Project# 1008800

Project Name: TIERRA VISTA UNIT 2 AT THE TRAILS

**Project #1008800 – Tierra Vista Unit 2 at the Trails
Amendment to Infrastructure List/Preliminary Plat**

**PRELIMINARY PLAT FOR
TIERRA VISTA UNIT 2
at the TRAILS**
(BEING A REPLAT OF TRACT B, TIERRA VISTA
UNIT 1 at the TRAILS) WITHIN
THE TOWN OF ALAMEDA GRANT
PROJECTED SECTION 16, TOWNSHIP 11 NORTH,
RANGE 2 EAST
NEW MEXICO PRINCIPAL MERIDIAN
CITY OF ALBUQUERQUE
BERNALILLO COUNTY, NEW MEXICO
JULY, 2011

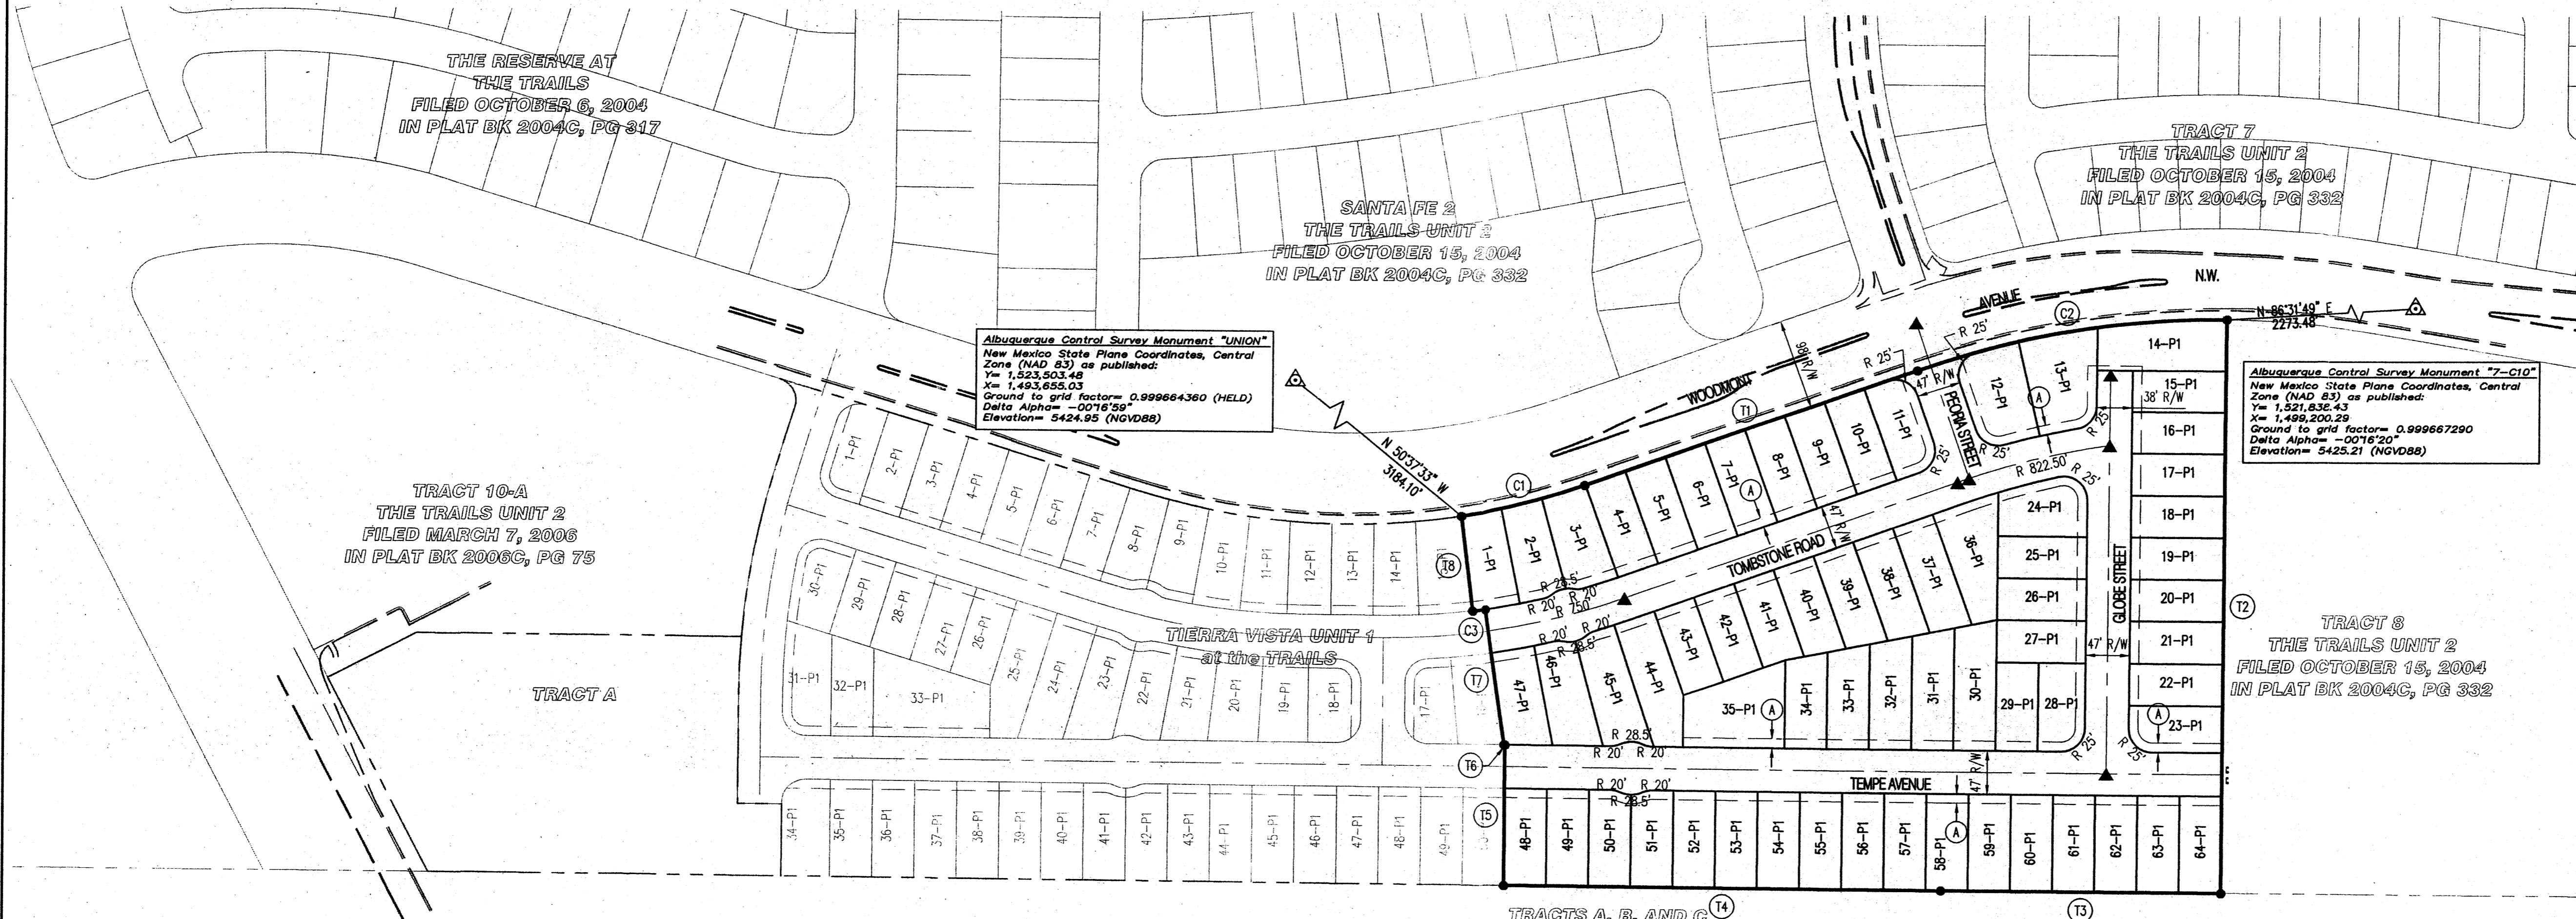
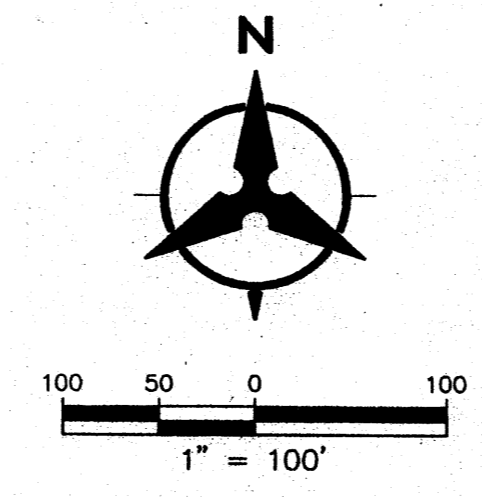
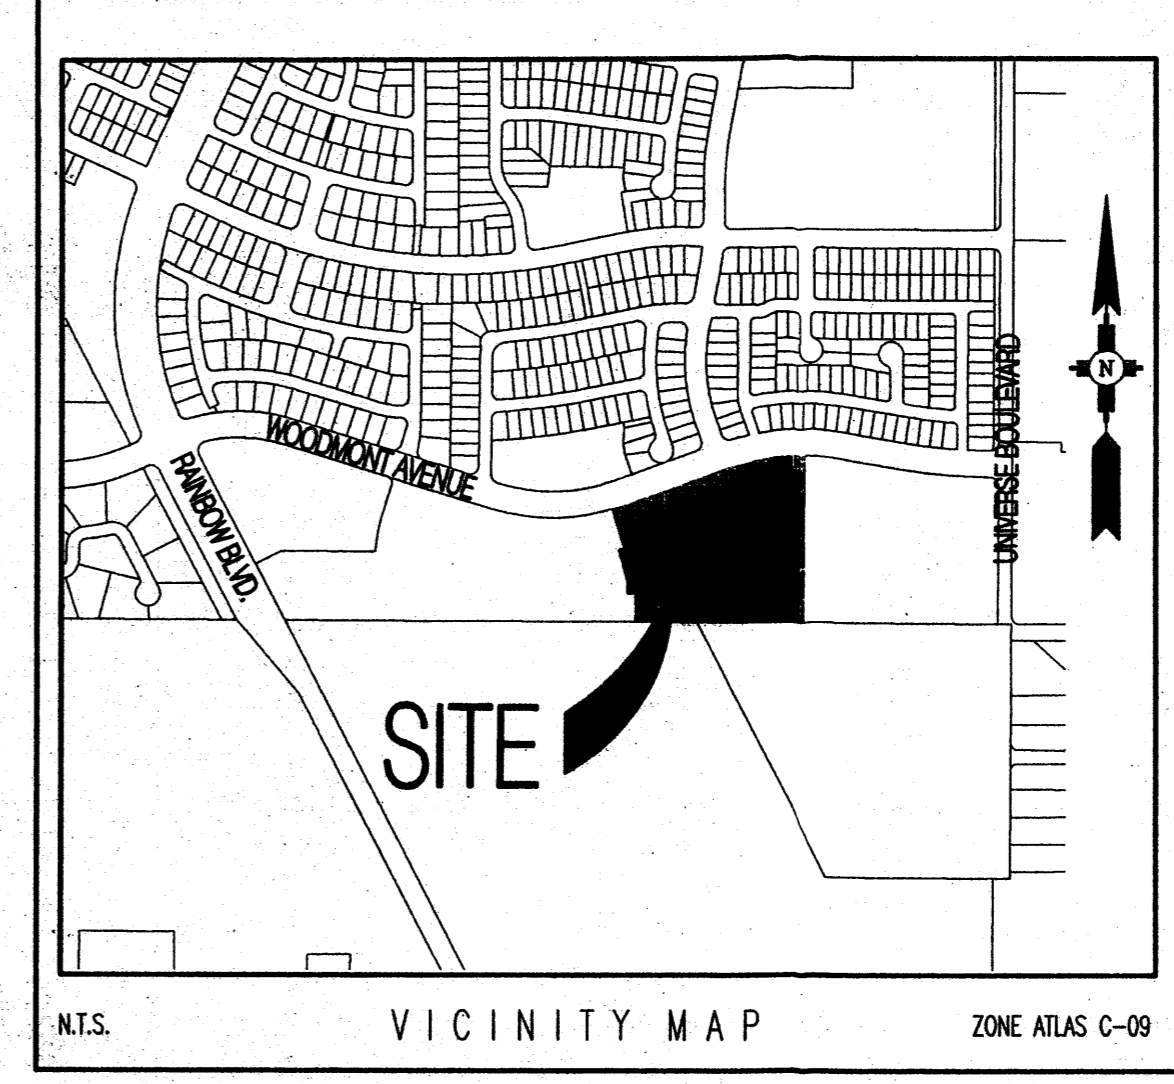
The vicinity map provided on the plat should call out Universe, not University, Boulevard.

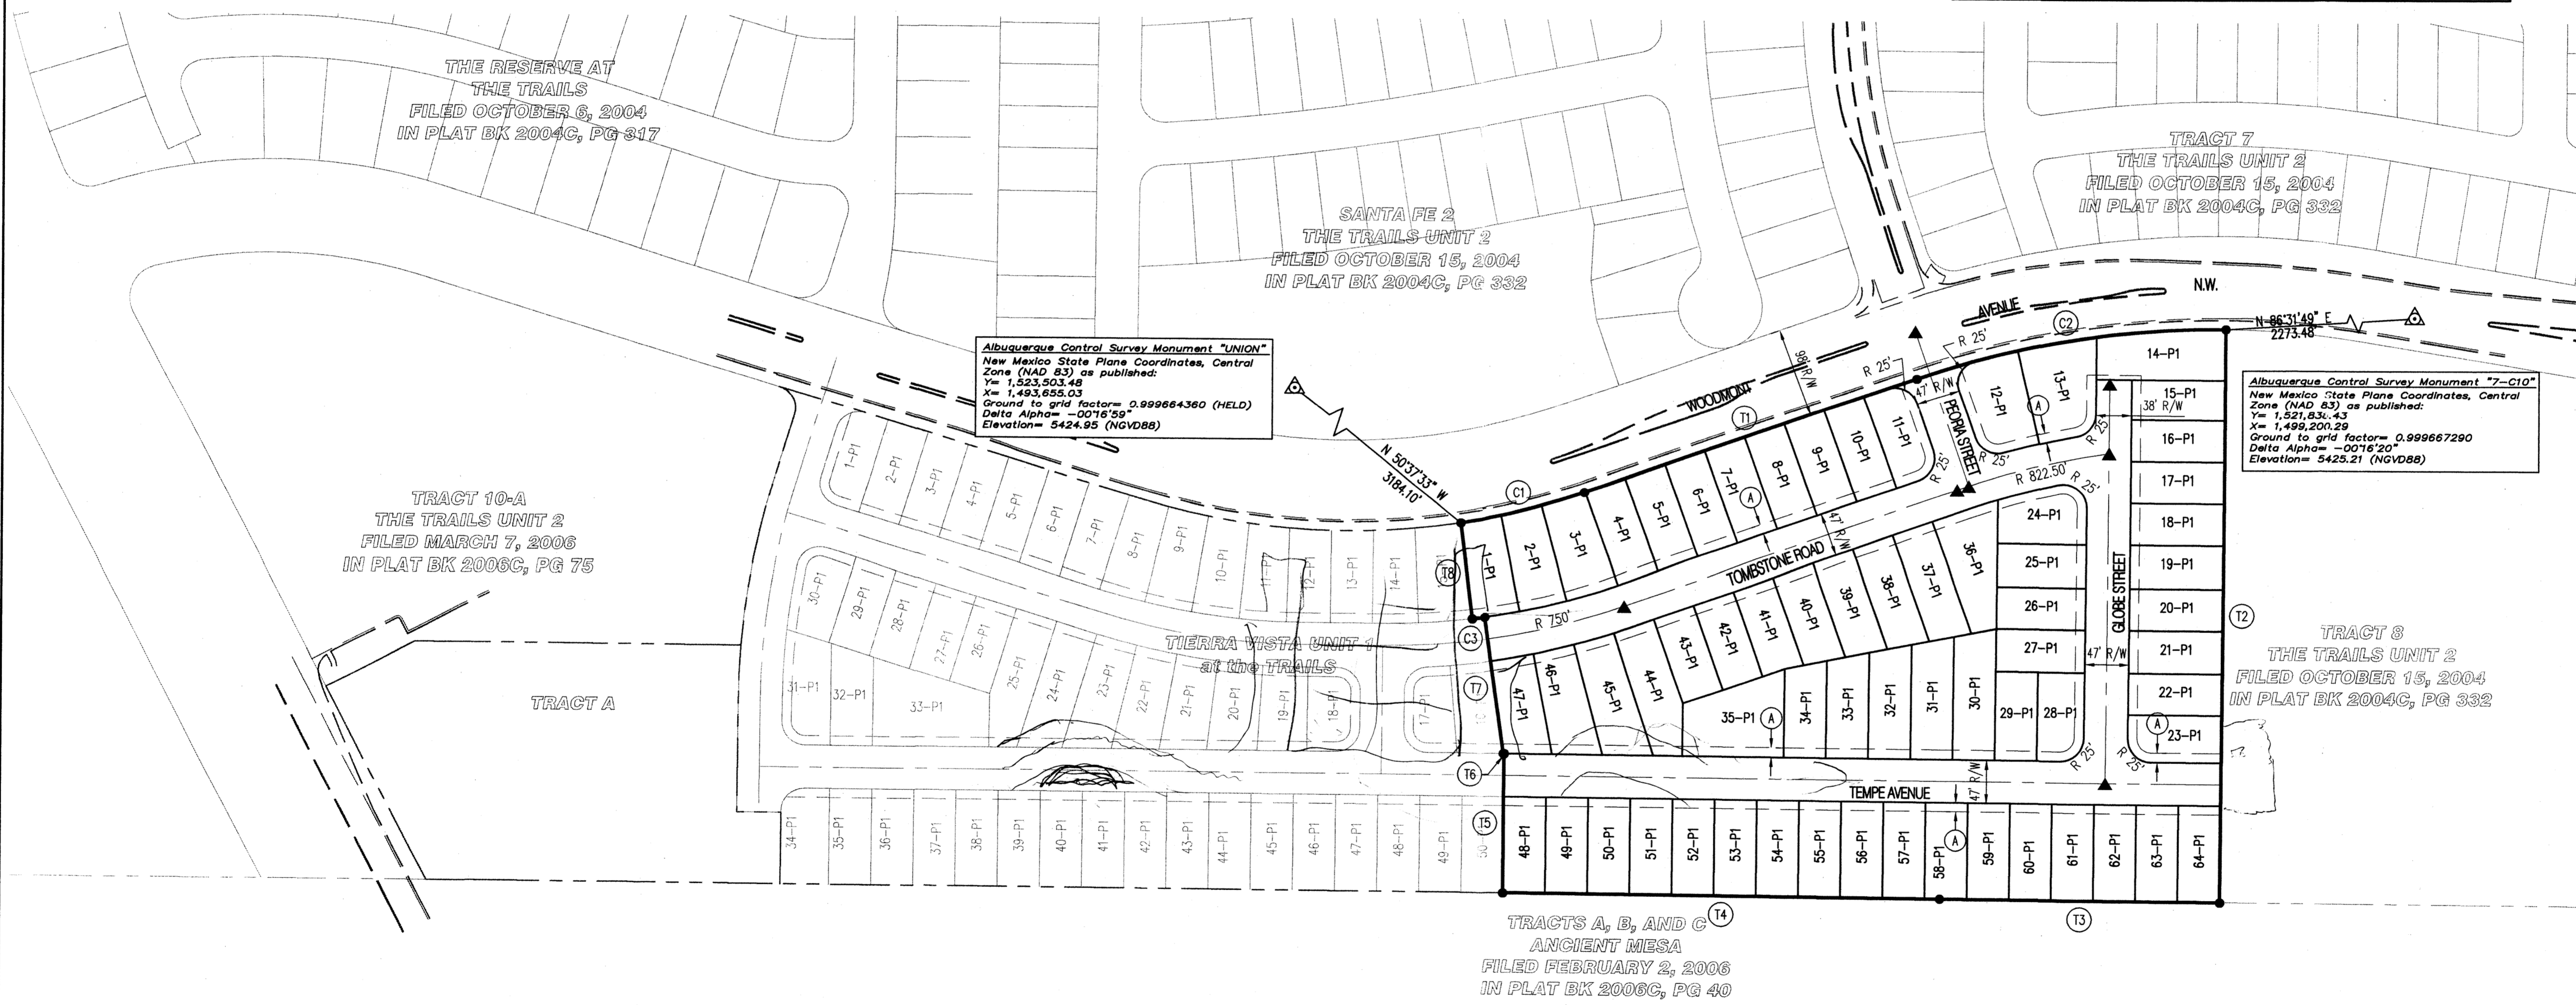
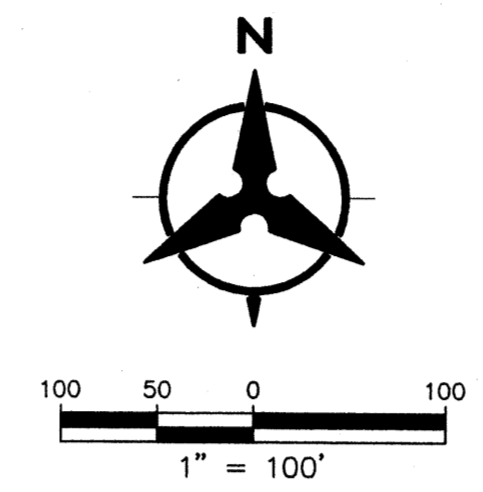
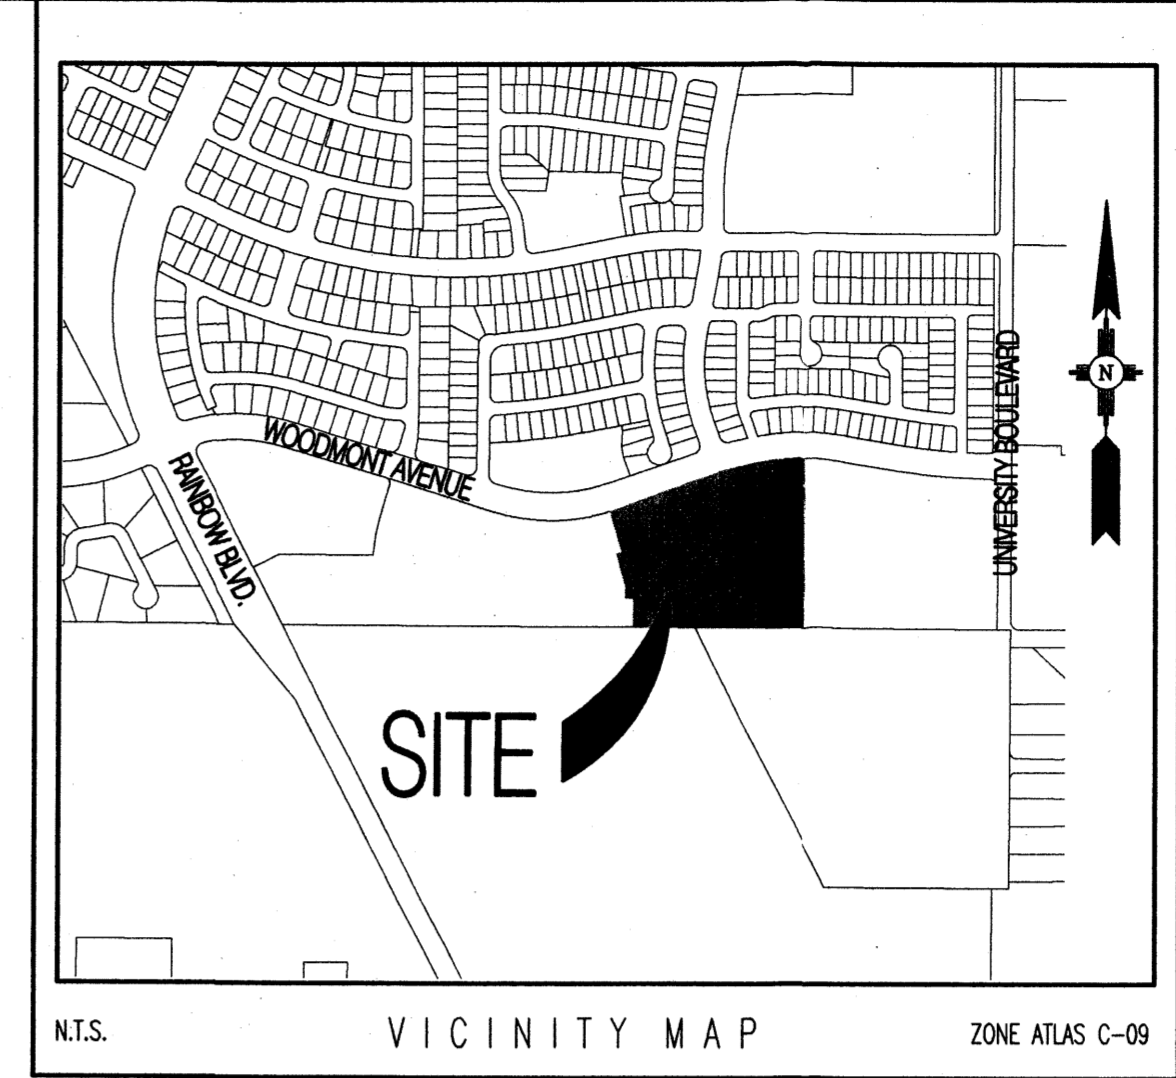
Peoria Street from Tombstone Road to Woodmont Avenue is classified as a normal local roadway. As such, it must have a minimum of 49 feet of right of way. See Table 23.2.1C of the *Development Process Manual*.

Globe Street from Tempe Avenue to Tombstone Road is classified as a normal local roadway. As such, it must have a minimum of 49 feet of right of way. See Table 23.2.1C of the *Development Process Manual*.

Tombstone Road from Globe Street to Peoria Street is classified as a normal local roadway. As such, it must have a minimum of 49 feet of right of way. See Table 23.2.1C of the *Development Process Manual*.

The vicinity map provided on the plat should call out Universe, not University, Boulevard.
No objection to sidewalk deferral and sidewalk waiver request.
